**PR-2024-010457**

SD-2024-00103  
PRELIMINARY/ FINAL PLAT  
IDO -2022

CSI – CARTESIAN SURVEYS INC. agent for RIO GRANDE FOOD PROJECT requests the aforementioned action(s) for all or a portion of: LOT C, BLOCK J, NORTHERN HEIGHTS zoned R-1B, located at 600 COORS BLVD NW between DAYTONA RD NW and FORTUNA RD NW containing approximately 2.4077 acre(s). (J-11)

**REQUEST:** Create 2 new lots from 1 existing lot, grant 5 ft PUE along Coors and Daytona frontages

Plat for
Lots C-1 and C-2, Block J
Northern Heights
Being Comprised of
Lot "C" and Southerly Portion of
A Vacated Alley, Block J
Northern Heights
City of Albuquerque
Bernalillo County, New Mexico
March 2024

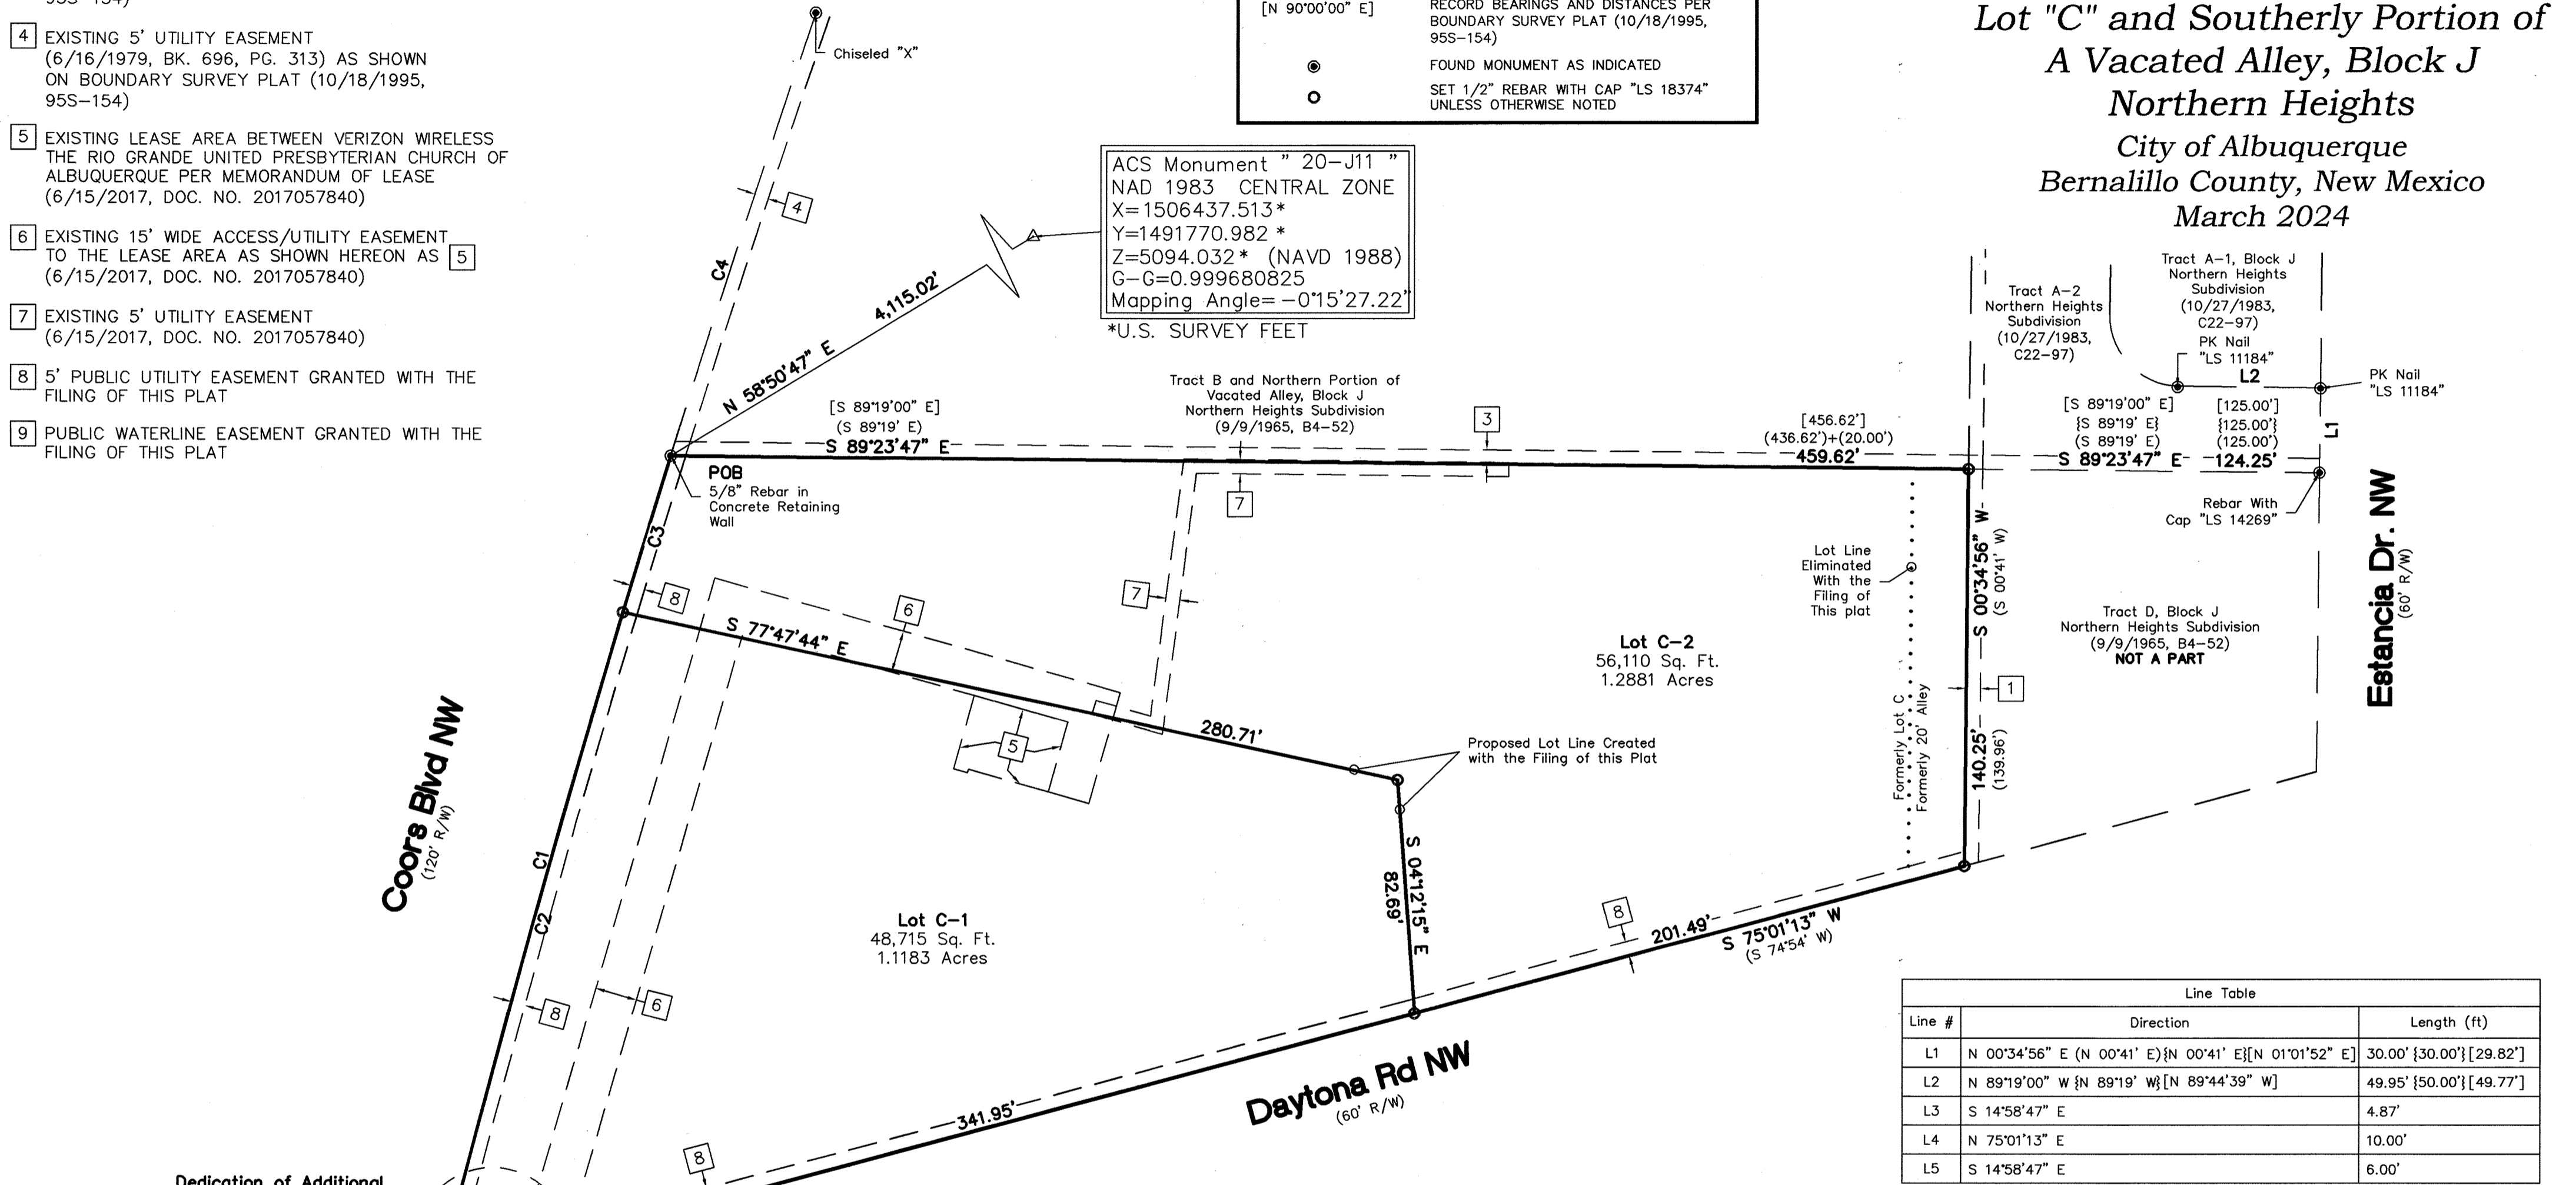
1. No objection. However, please add the following note to the plat:
  - a. “Existing public water and/or sanitary sewer infrastructure may not be constructed or sized to adequately serve potential future development. Improvement or upsizing of existing public infrastructure may be required as a condition of future development approval.”

1. Coors is a Principal Arterial and a Major Transit Corridor. Daytona is a local road. Existing sidewalks along both roadways meet requirements listed in the DPM.
2. Please provide ROW dedication at the intersection to keep sidewalk within ROW. Currently the property line clips the sidewalk at this intersection.
3. For future development an approved TCL will be required prior to site plan or building permit. Also, a Traffic Scoping form will need to be filled out and submitted to Curtis Cherne ([ccherne@cabq.gov](mailto:ccherne@cabq.gov)) to determine if a TIS will be required.

***\*Verification of standards per Transportation\****  
*Coors is a Principal Arterial and a Major Transit Corridor. Daytona is a local road. Existing sidewalks along both roadways meet requirements listed in the DPM.*  
*Please provide ROW dedication at the intersection to keep sidewalk within ROW. Currently the property line clips the sidewalk at this intersection.*
